Recommendation Report for Prior Notification for Householder Extension

REF NO: R/107/18/PDH

LOCATION: 23 Preston Avenue
Rustington
BN16 2DF

PROPOSAL: Notification under extended permitted development rights for a single storey rear extension extending 6.5m from the rear of the original dwelling house, with a maximum height of 2.85m & an eaves height of 2.85m.

Drawing Reference:
PA.CON.FP.002

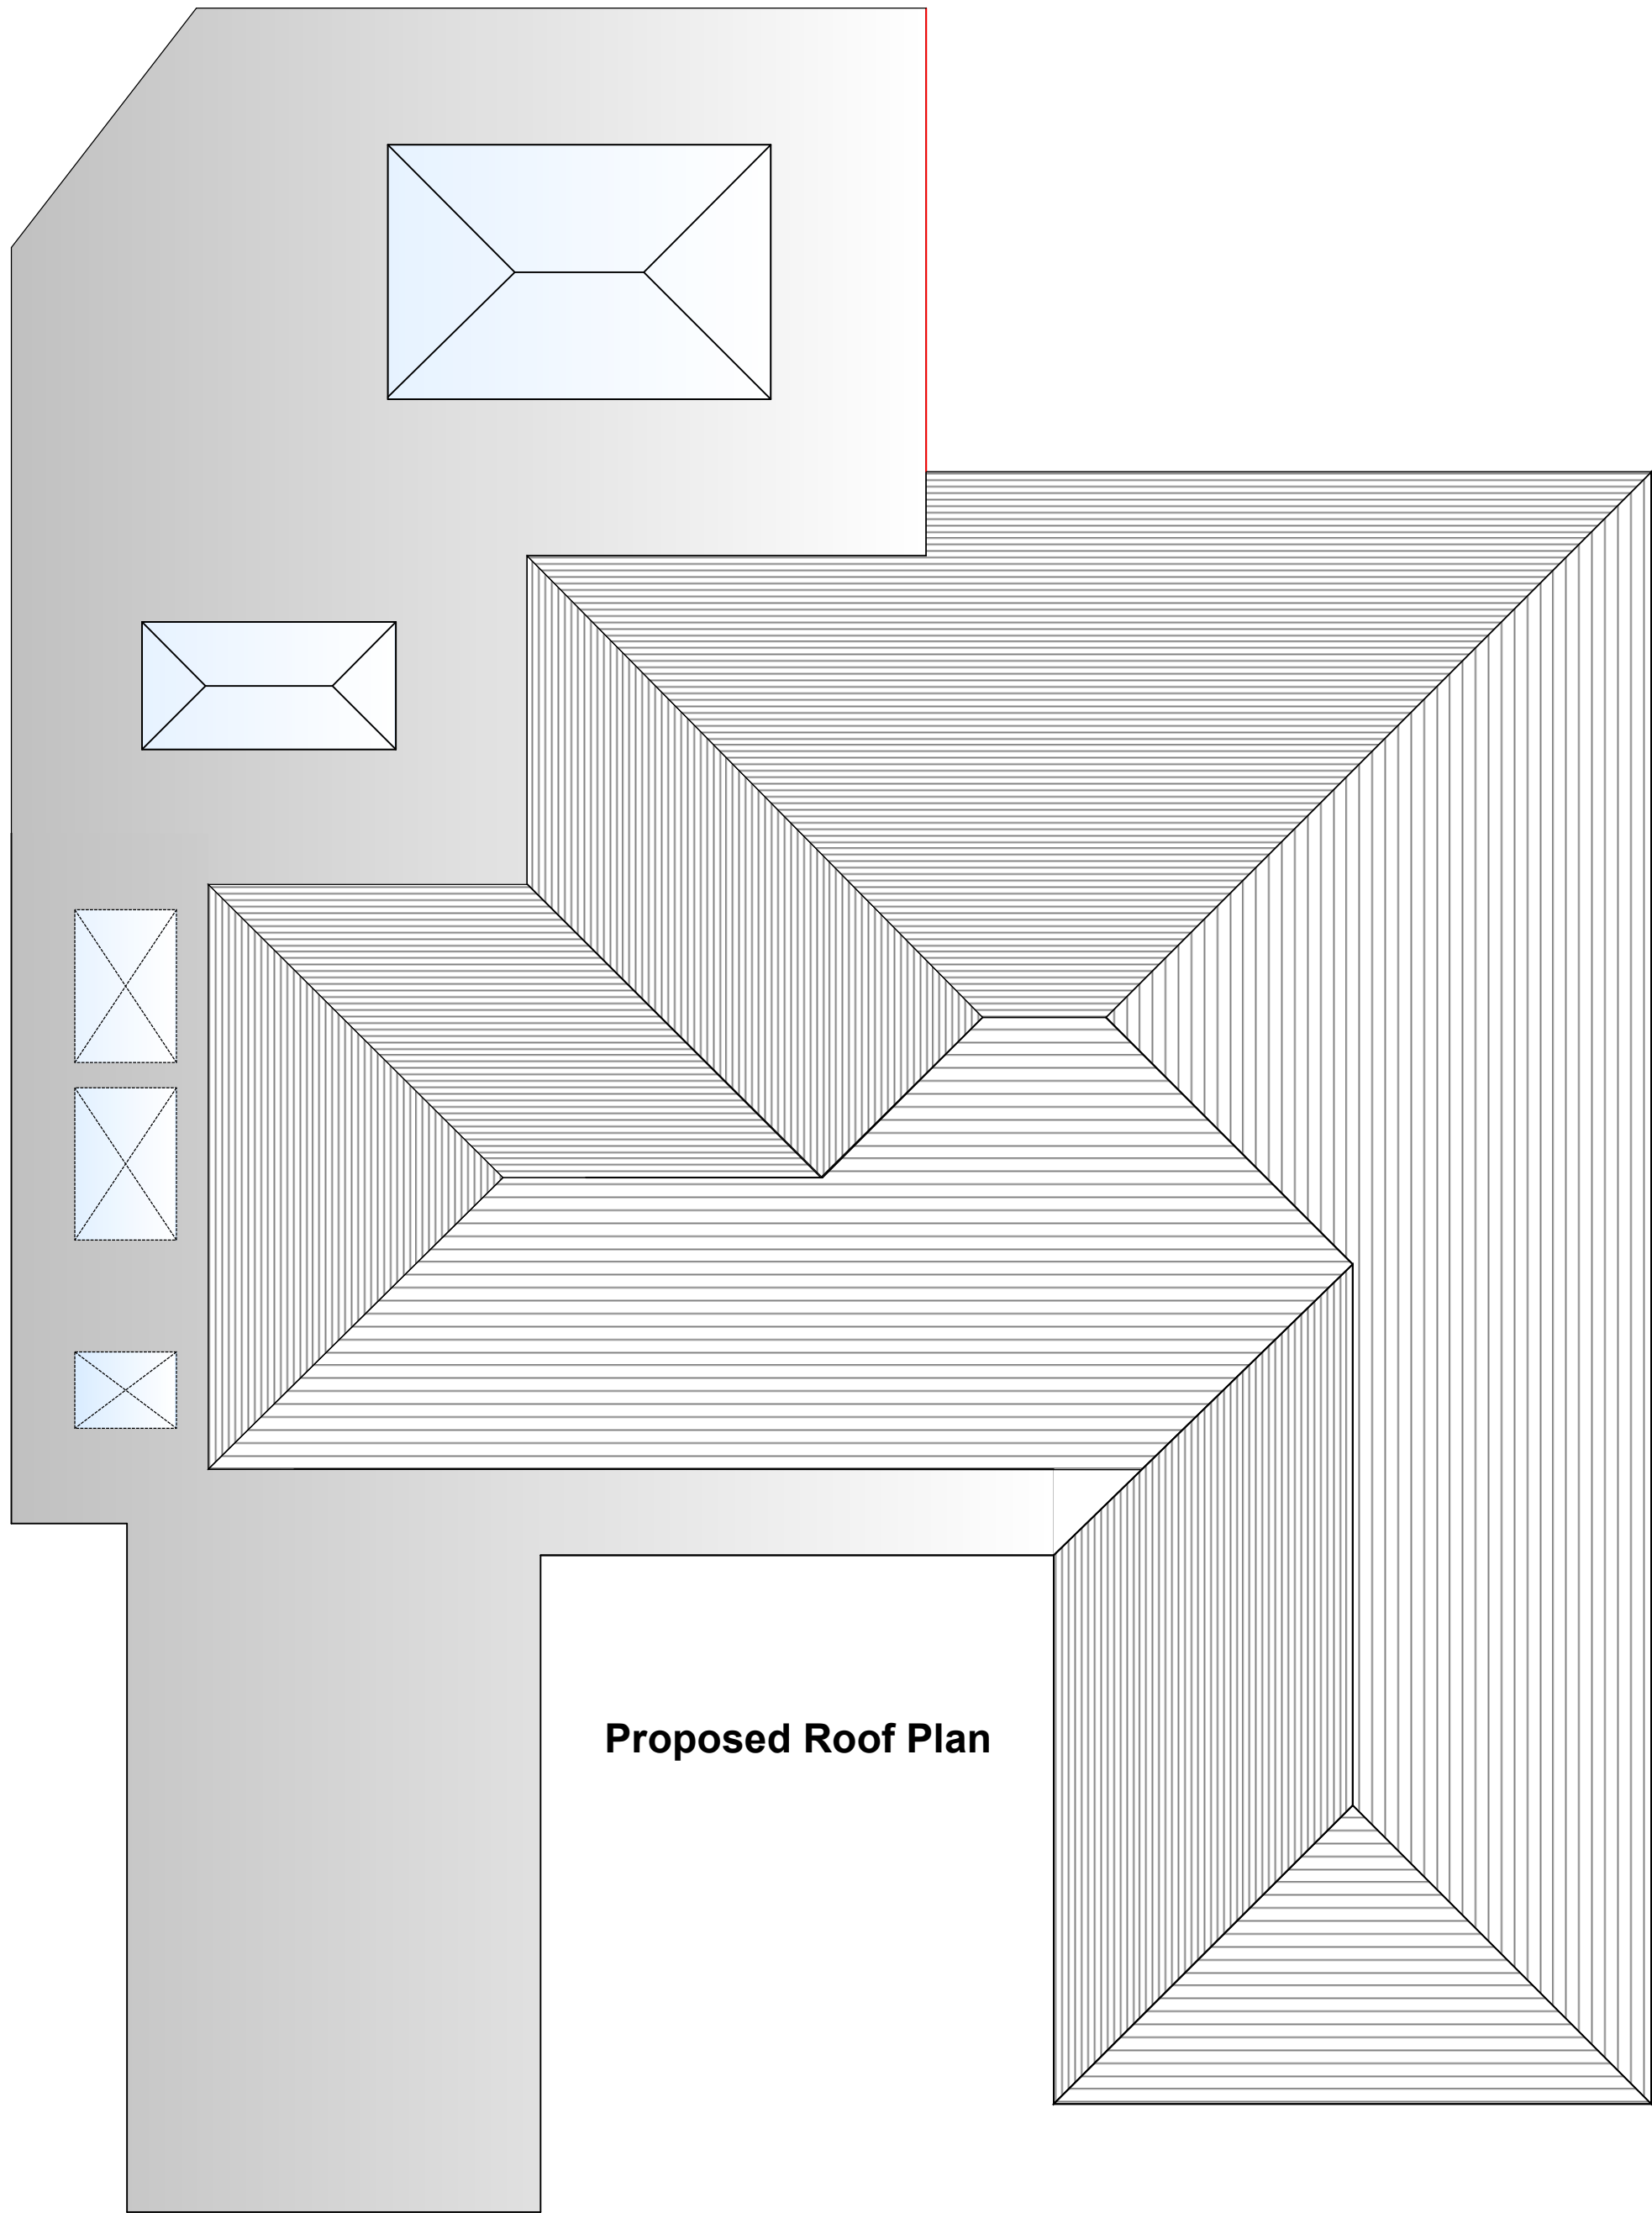
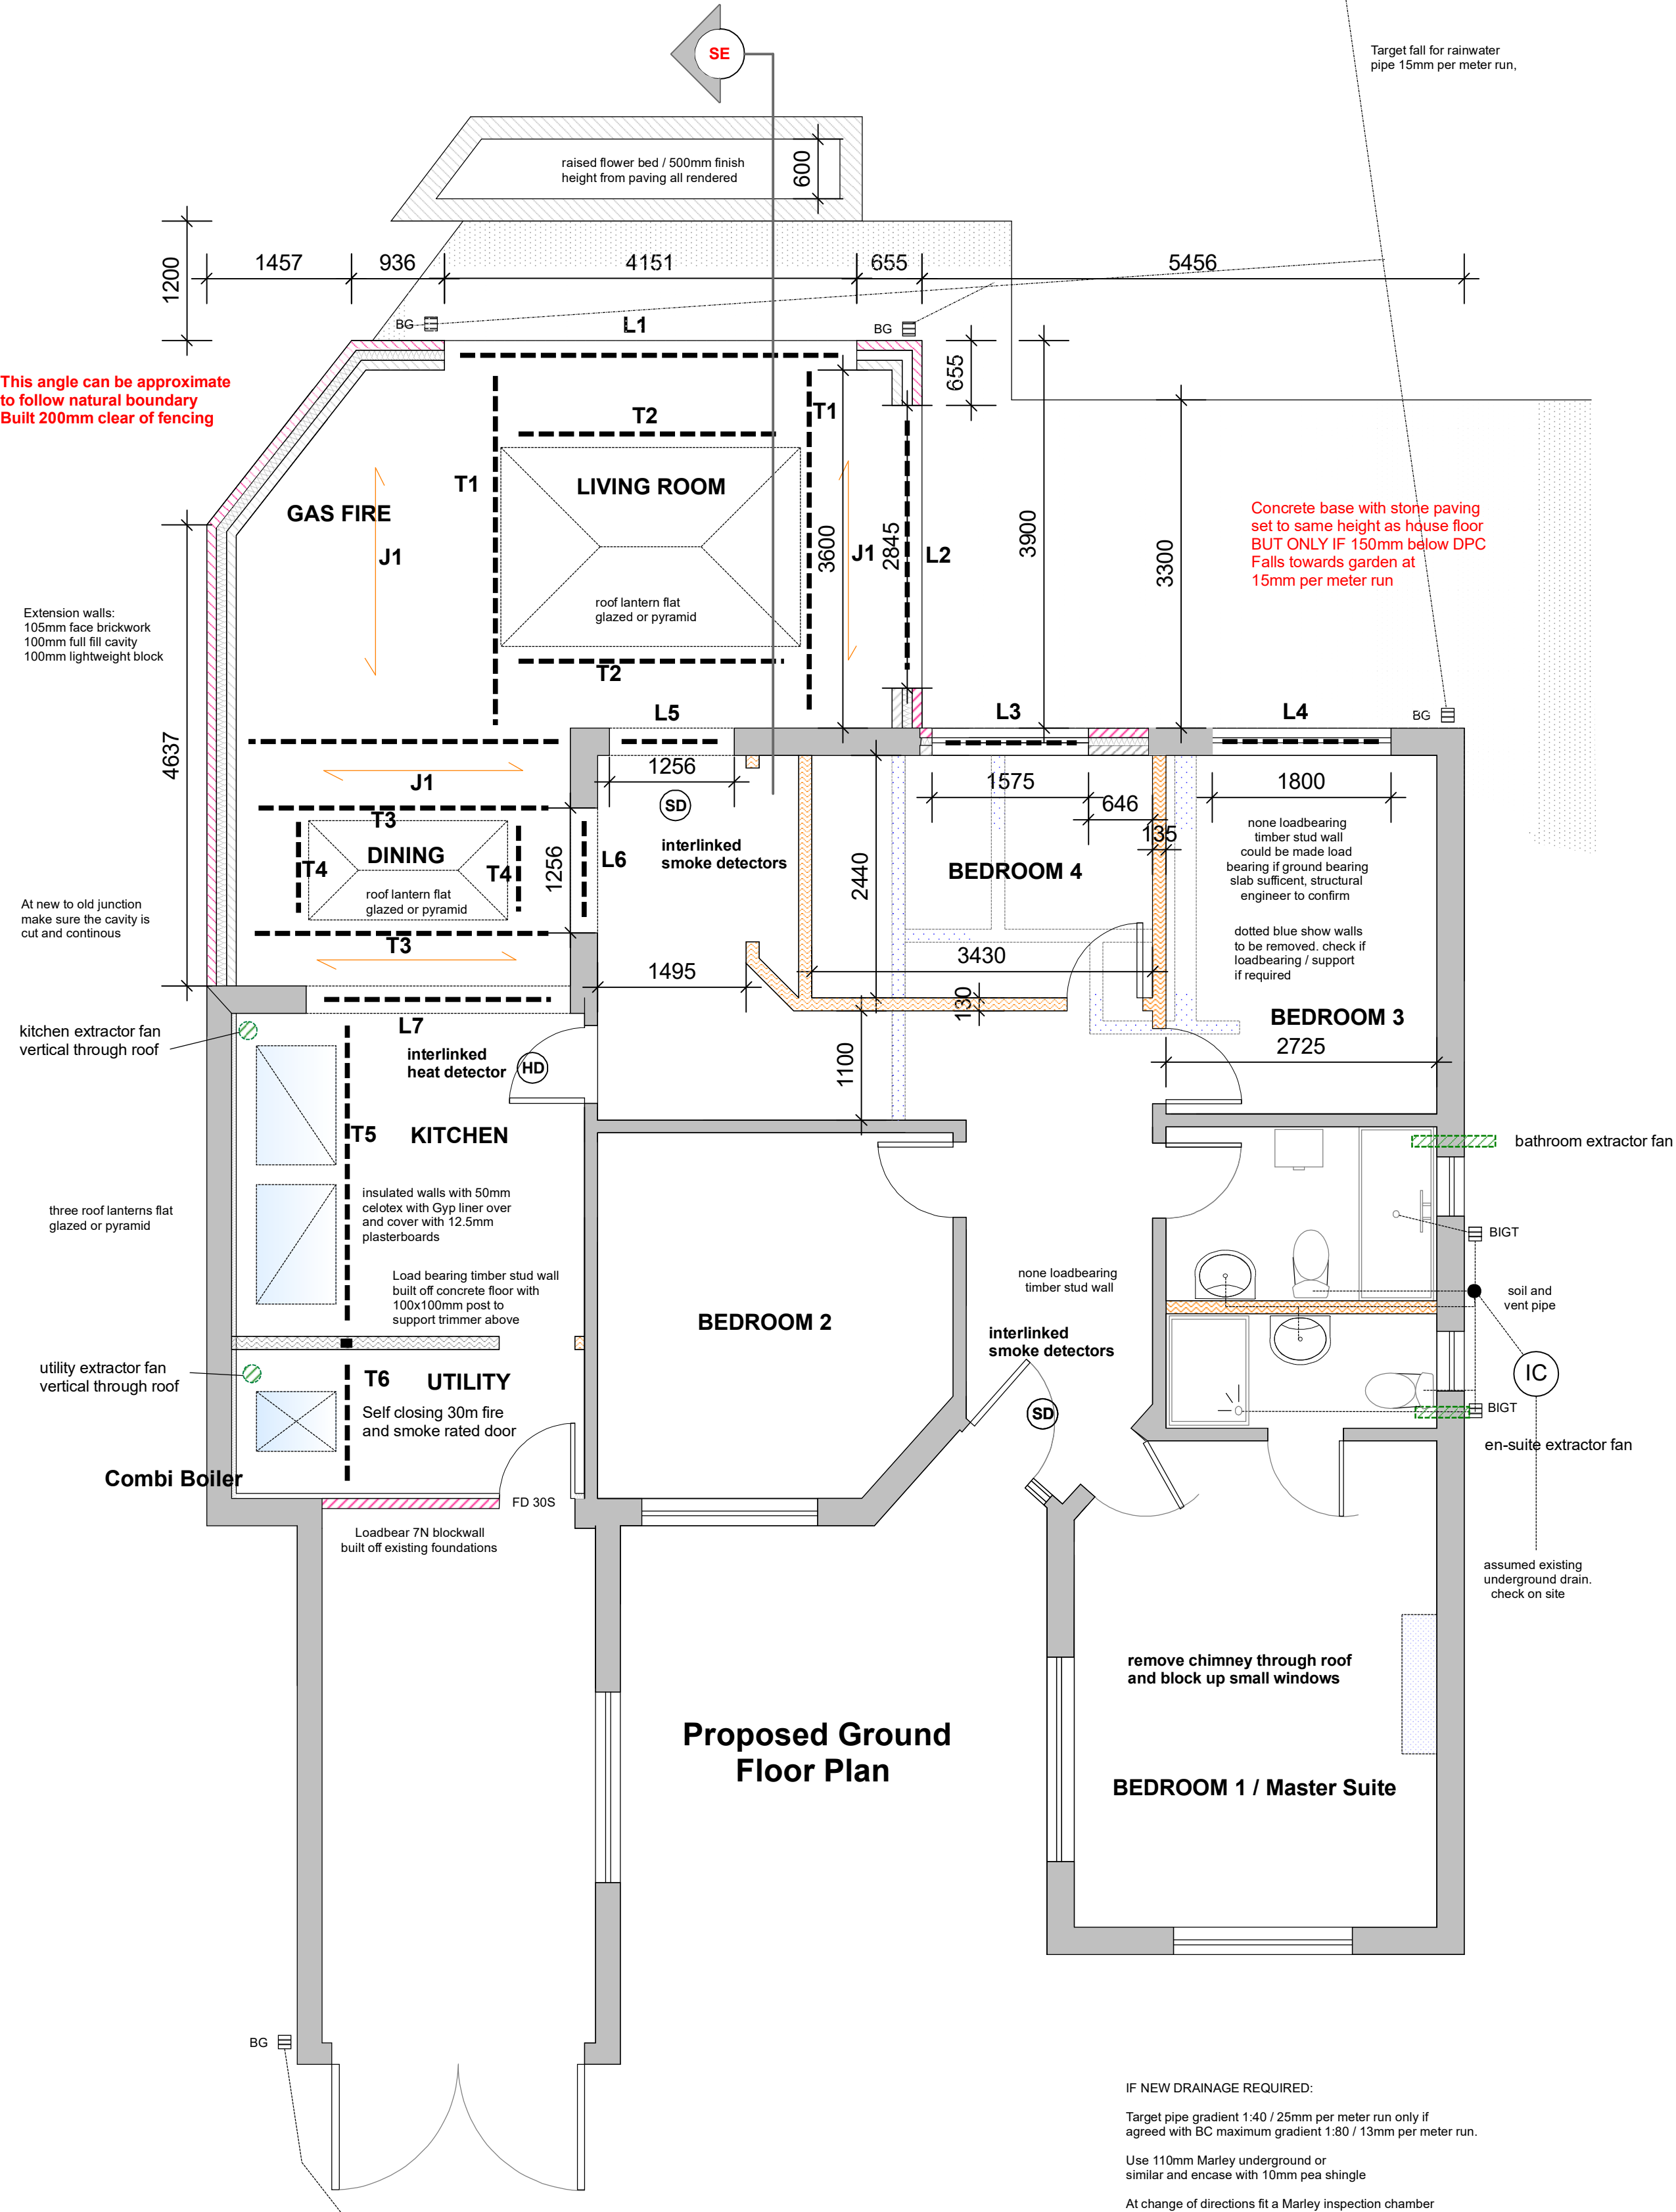
- Extension is too high and too close to the boundary
- Doesn't comply with legislation in that the height is higher than the eaves height.
- Doesn't comply with legislation in that the roof height would mean alterations to link to the existing roof
- Roof lanterns would increase adverse visual impacts
- Out of character with other properties
- Block plan is misleading
- Room should be allowed for maintenance to boundaries walls.
- Depth of the property will increase by 50%
- Lack of natural ventilation means vapours/ odours from the kitchen will vent to neighbouring properties
- Re-configuration of the internal dwelling will be different to neighbouring properties

The roof is to be constructed as a flat roof and as shown in the plan there is no alteration to the existing roof.

The proposed extension will have a maximum depth of 6.5m to the western elevation as it infills the rear of the dwelling. It will run alongside the boundary to No.21 and will have a width of around 5.75m where the depth will reduce to 4m from the original rear wall of the dwelling. Due to the location and boundary treatment, the proposed extension is not considered to impact the neighbouring properties at No.21 or No.25. The extension also has a separation distance of around 20m to No.7 and may only be slightly visible due to the boundary treatment and is therefore not considered to give rise to any overlooking, overbearing or overshadowing.

The proposed extension will be constructed to a height of 2.85m and will match that of the existing dwelling as shown in the approved plan and will be constructed with a flat roof. It should be noted that a structure can be constructed under Permitted Development to a height of 4m without the need for a formal planning application. In addition the presence of hedging of sufficient height will mean that there will not be an unacceptably adverse overbearing impacts upon the neighbouring property at No.7 or other adjoining neighbours. The proposal is also for this reason not considered to give rise to any loss of privacy due to outlook or any loss of light.
